**TWEED
SHIRE
COUNCIL**

Re: Major Project Application No. 06-0327 - Redevelopment of Twin Towns Services Club at Lot 1 DP 777183 Wharf Street, Tweed Heads

**Request for provision of details of key issues and assessment requirements -
MP 06_0237 - redevelopment of Twin Towns Services Club.**

TO : Garry Smith
FROM : Paul Morgan
SUBJECT : Twin Towns Services Club Expansion - Wharf Street
FILE :
DATE : 27 November 2006

PROPOSED CARPARKING ARRANGEMENTS

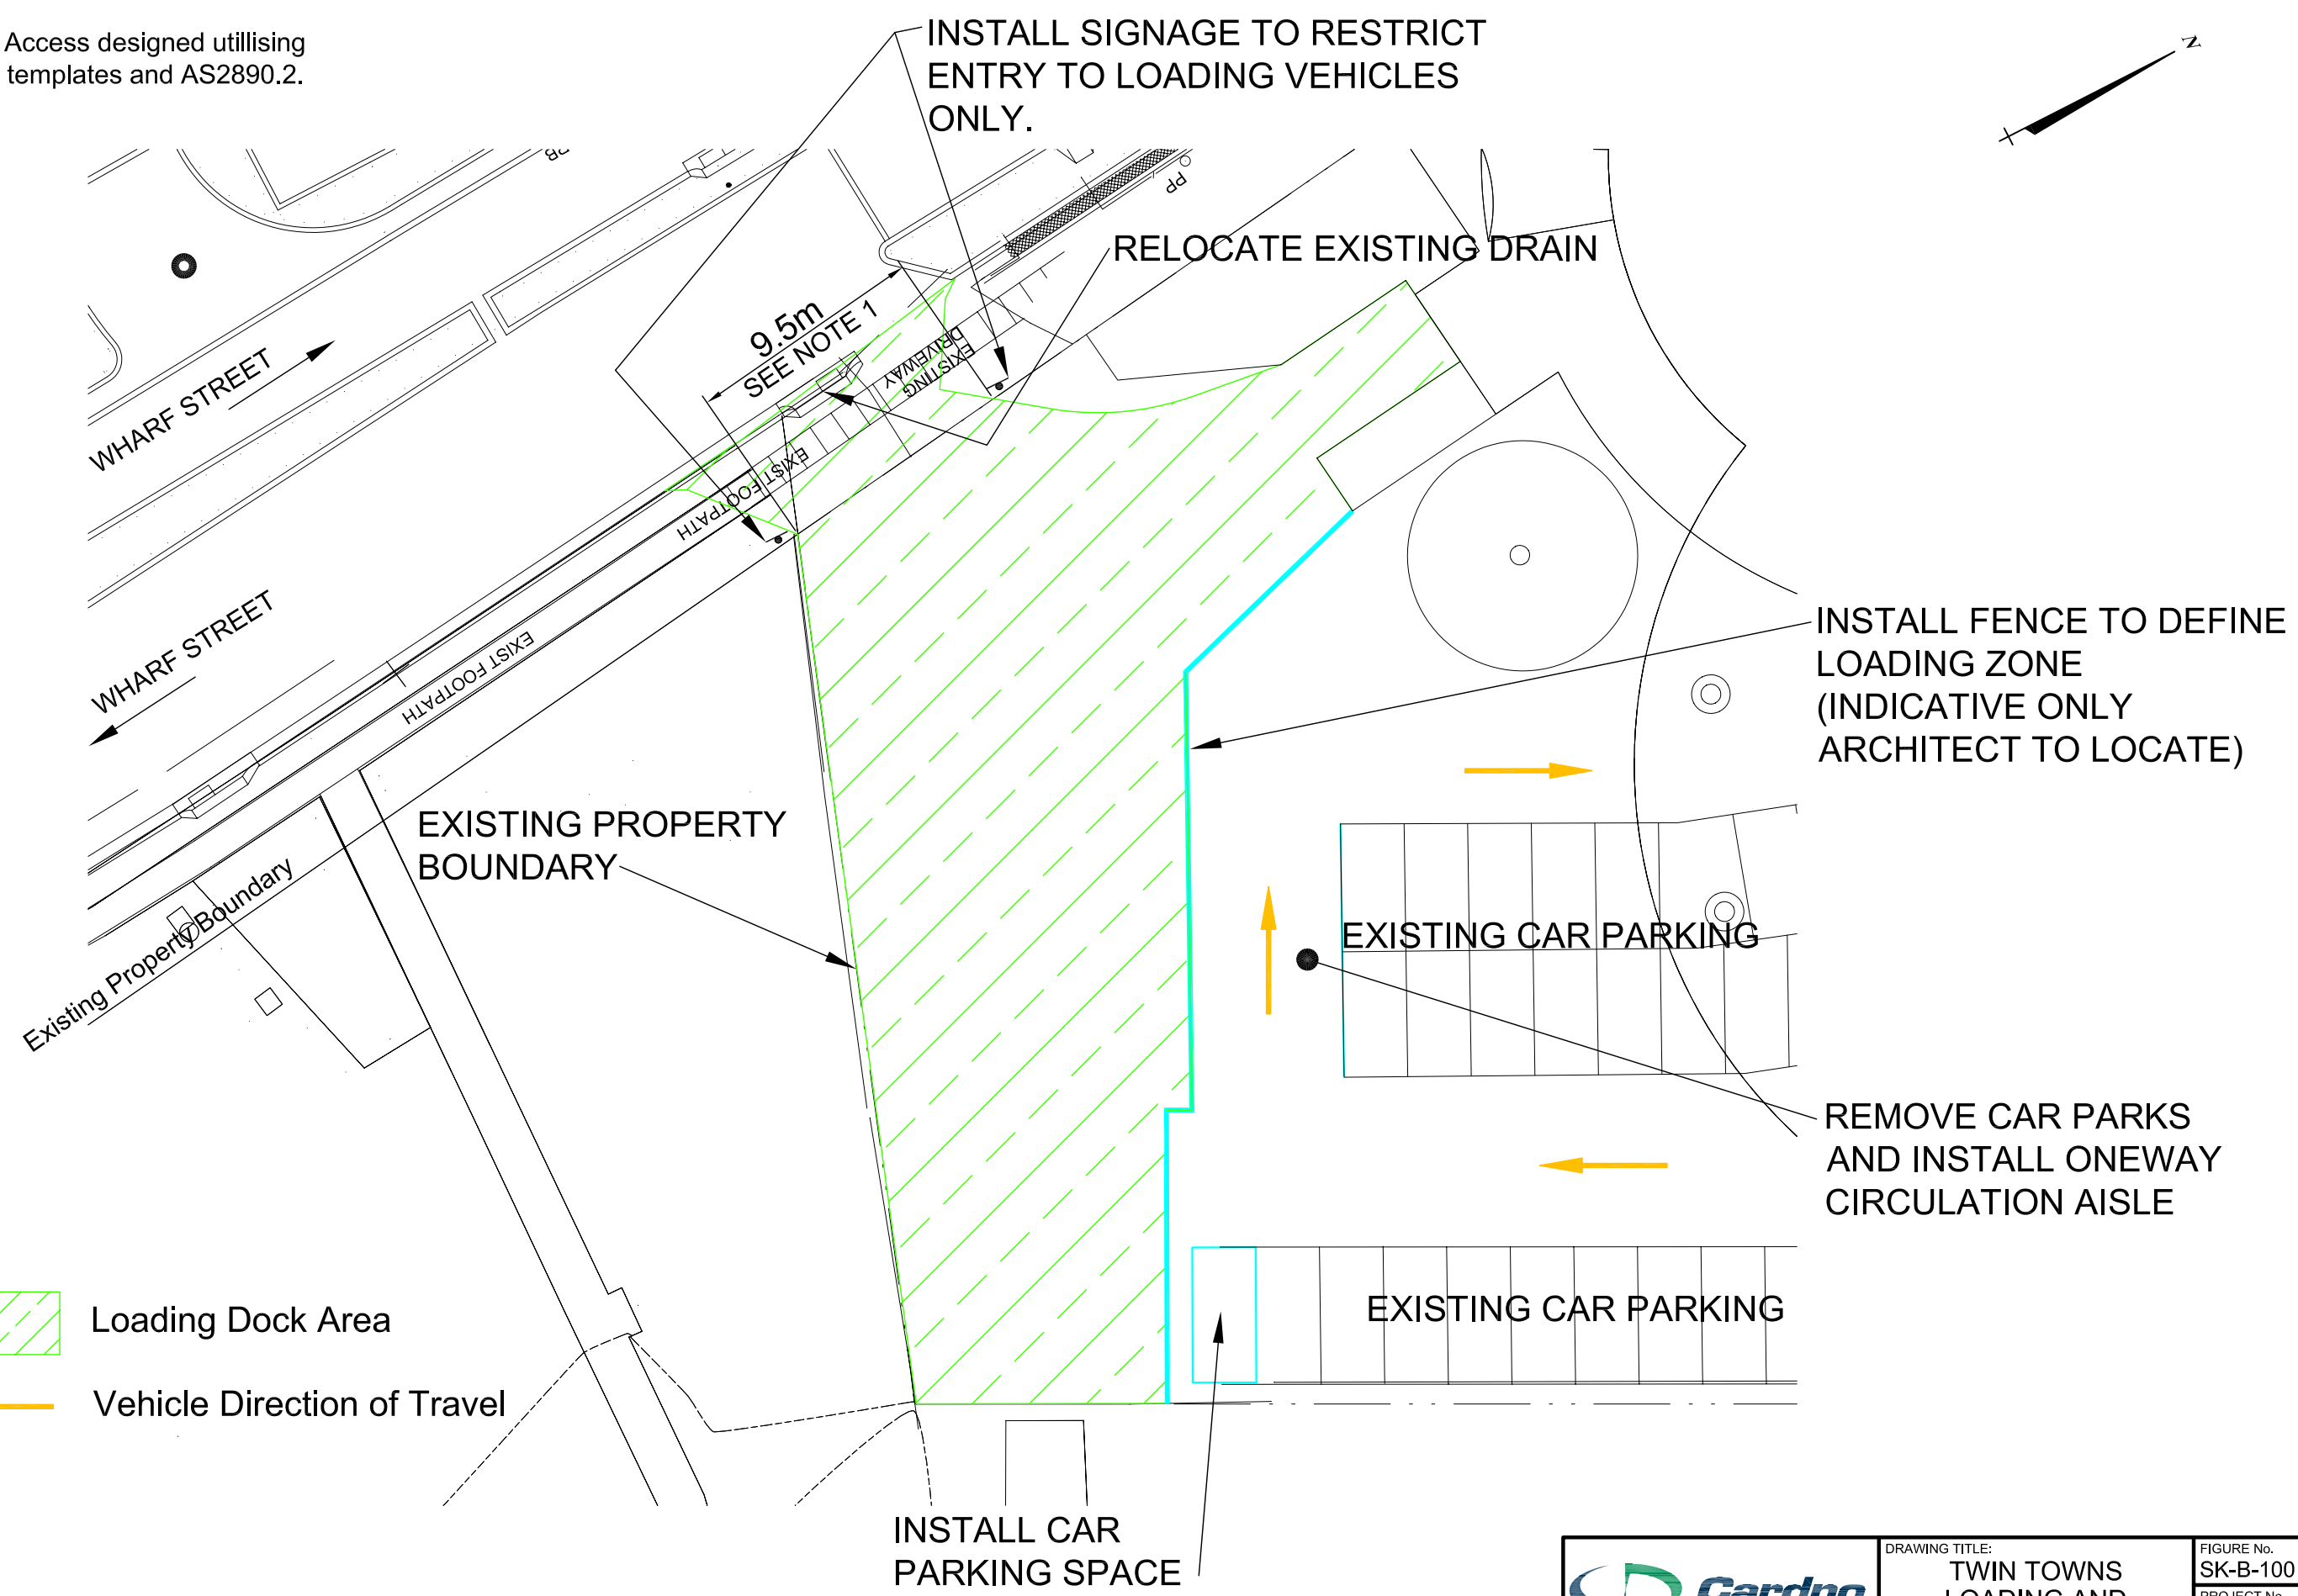
The proposed amendments to the Wharf Street pedestrian crossing are unacceptable in regards to pedestrian safety.

Currently the zebra crossing has 'kerb blister extensions' restricting the crossing width to 2 lanes of traffic, one in each direction.

The RTA at the instruction of the NSW Government are reviewing all zebra crossings that cross more than one lane in each direction. The proposal creates a new turn lane by removing the kerb blisters, resulting in pedestrians having to cross 2 lanes of southbound traffic which is undesirable and may not meet any new standards the RTA introduce. (NB Wollumbin St crossing in Murwillumbah is being replaced with signals for this reason.)

The proposal to construct an 'intersection' at the access road at Wharf Street is unacceptable as it takes away pedestrian priority on the footpath. The new zebra crossing shown across the access road won't be permissible under RTA specifications, therefore the only acceptable access arrangement is a Driveway Crossover to maintain pedestrian priority. The width of the access driveway needed to cater for truck entry is excessive and out of character with the area.

A potential solution is for the applicant to fund signaling the pedestrian crossing, but RTA approval of such is required.

This matter should be referred to the RTA for further comment as it is inappropriate in my opinion to reduce the level of service and safety of pedestrians to facilitate this proposal.

DRAWING TITLE:	FIGURE No.
	TWIN TOWNS	SK-B-100
	LOADING AND	PROJECT No.
	PUBLIC ACCESS	CE008530
DATE		30/05/2007

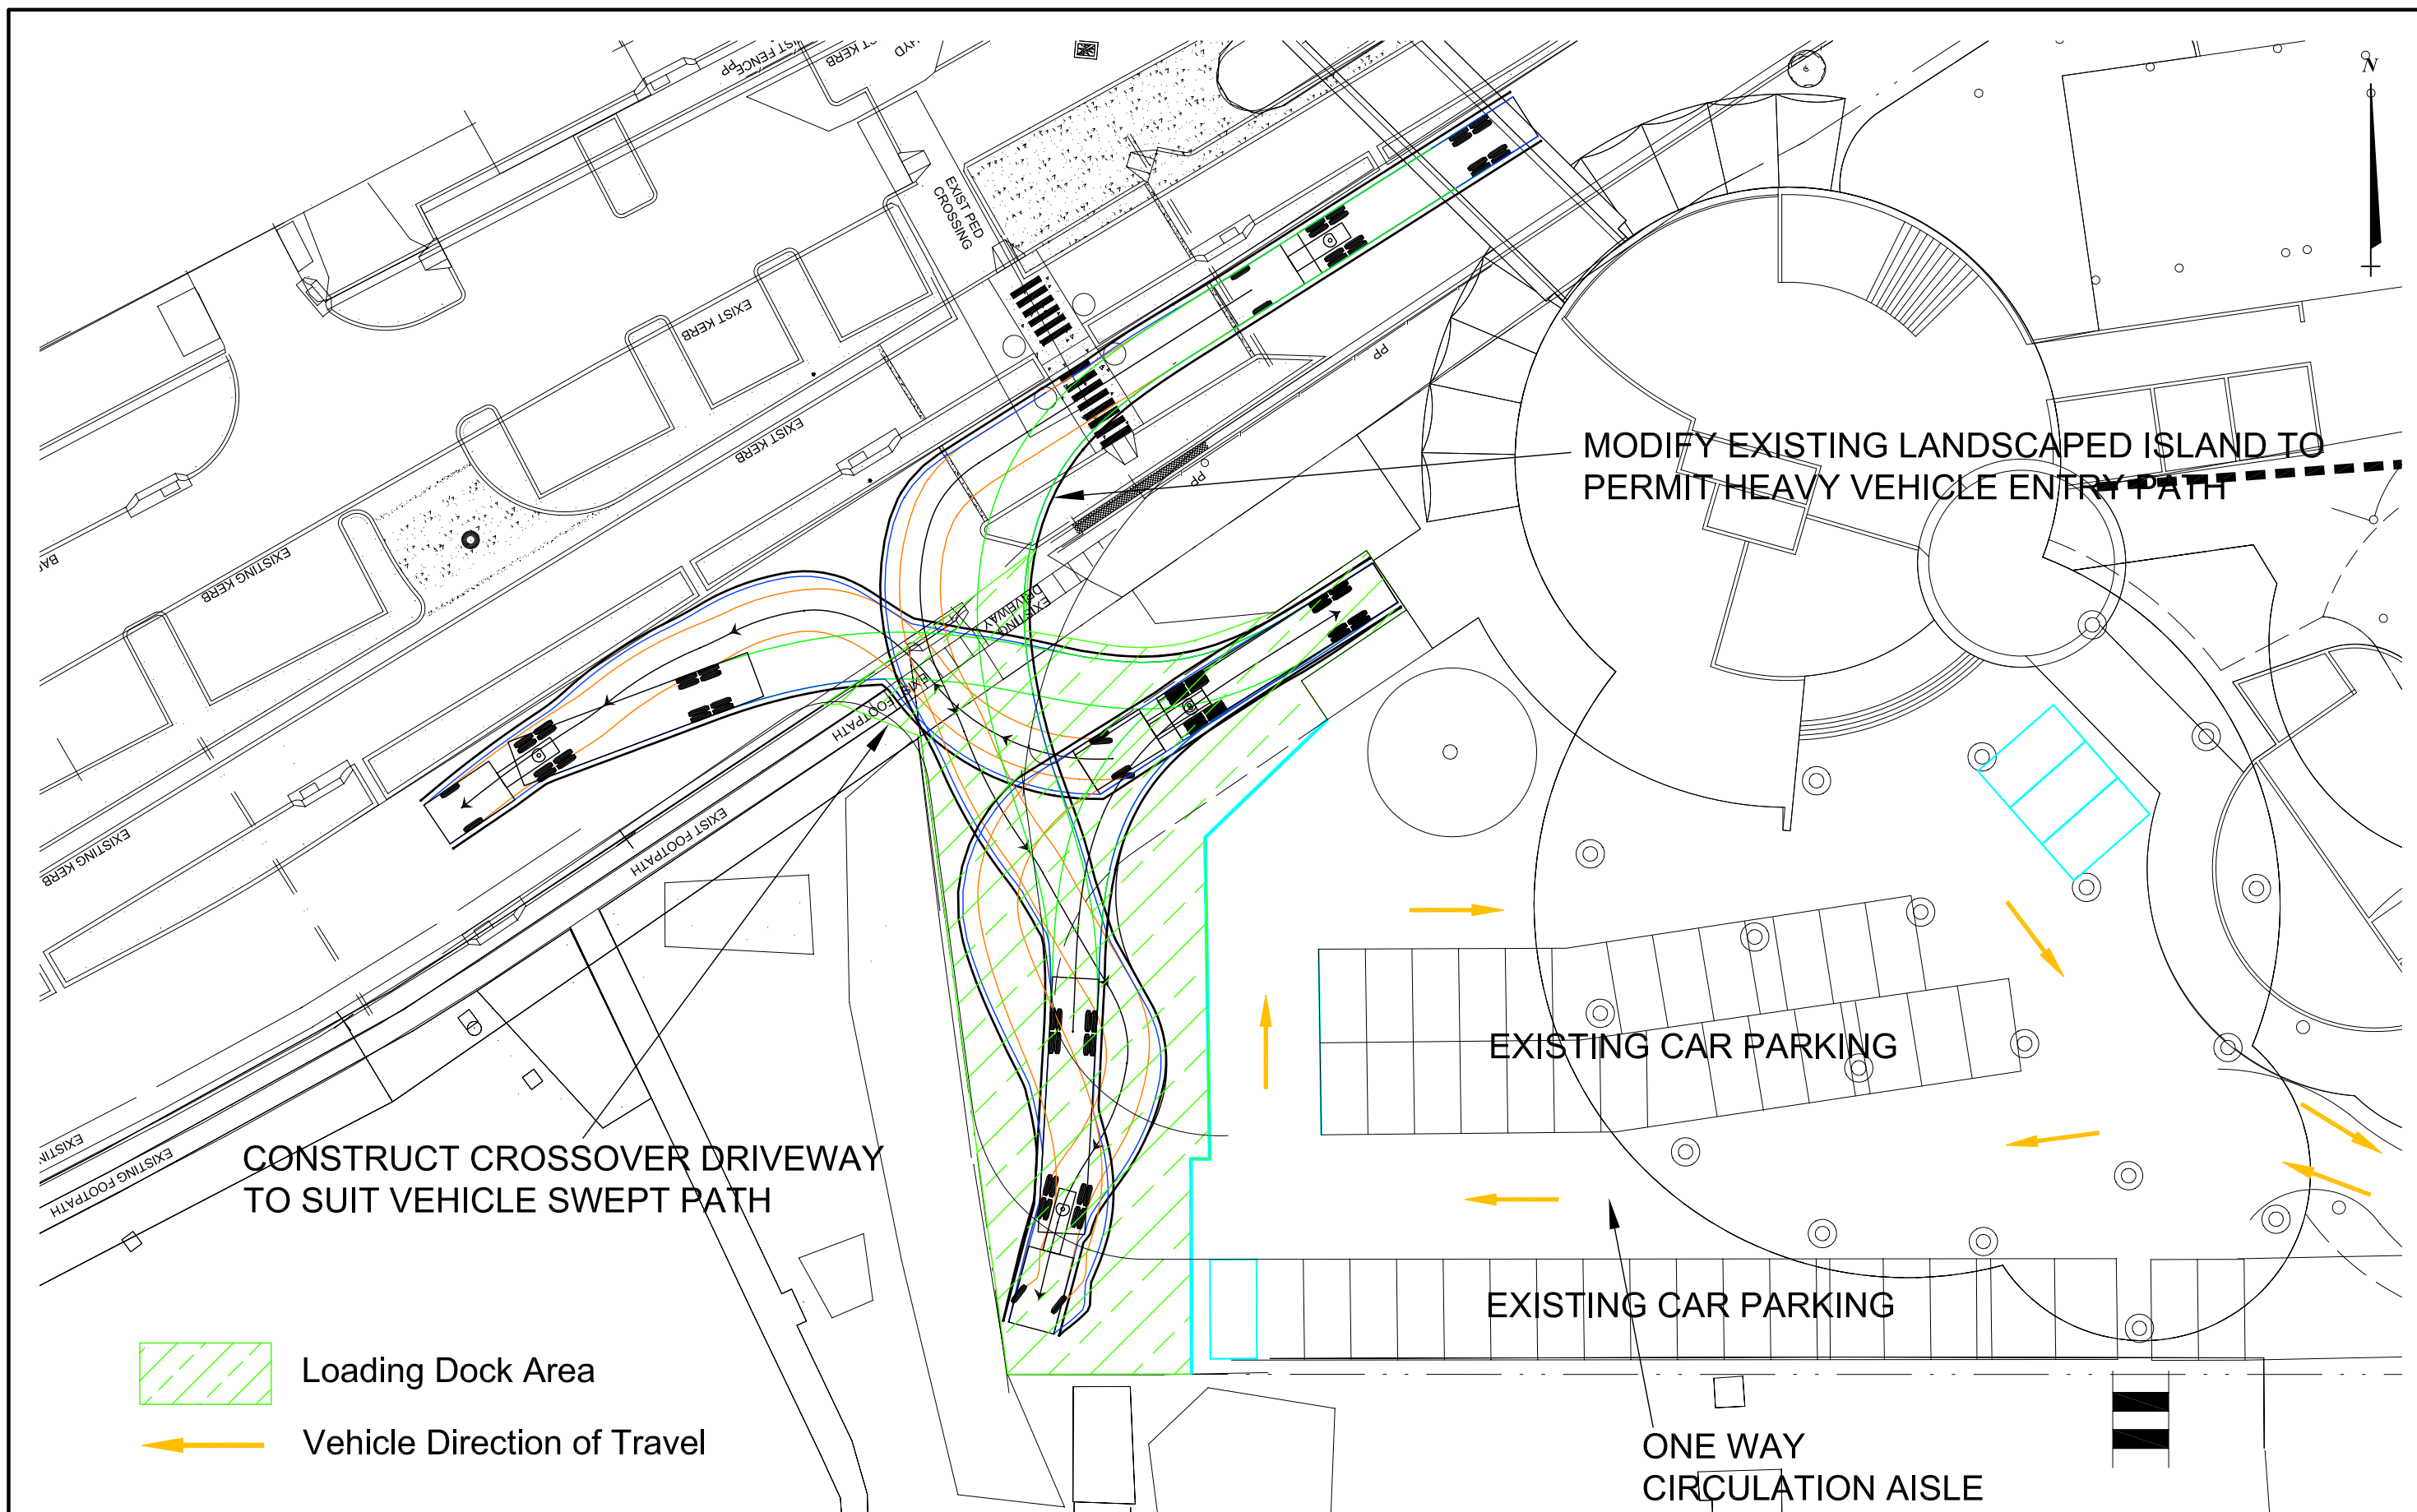
The loading bay does not comply with TSC DCP2 or AS2890.2 as the manoeuvring area for delivery trucks is the access road to the car park.

In the location shown, it is highly probable given the size of the car park that cars will be forced to queue onto Wharf Street, blocking a high use footpath and the zebra crossing whilst delivery trucks manoeuvre into and out of the loading bay, and accordingly should not be supported.

In addition to (2) above, it appears the building physically covers all the access traffic isles through the car park to Boundary Street, which appears to result in service vehicles reversing out of the loading bay into Wharf Street.

This may not be a problem if clearance of at least that required for a garbage truck is provided under the building.

The obvious solution is to have loading bays accessible from Boundary Street which has much less pedestrian and vehicular traffic, and have an exit only onto Wharf Street.
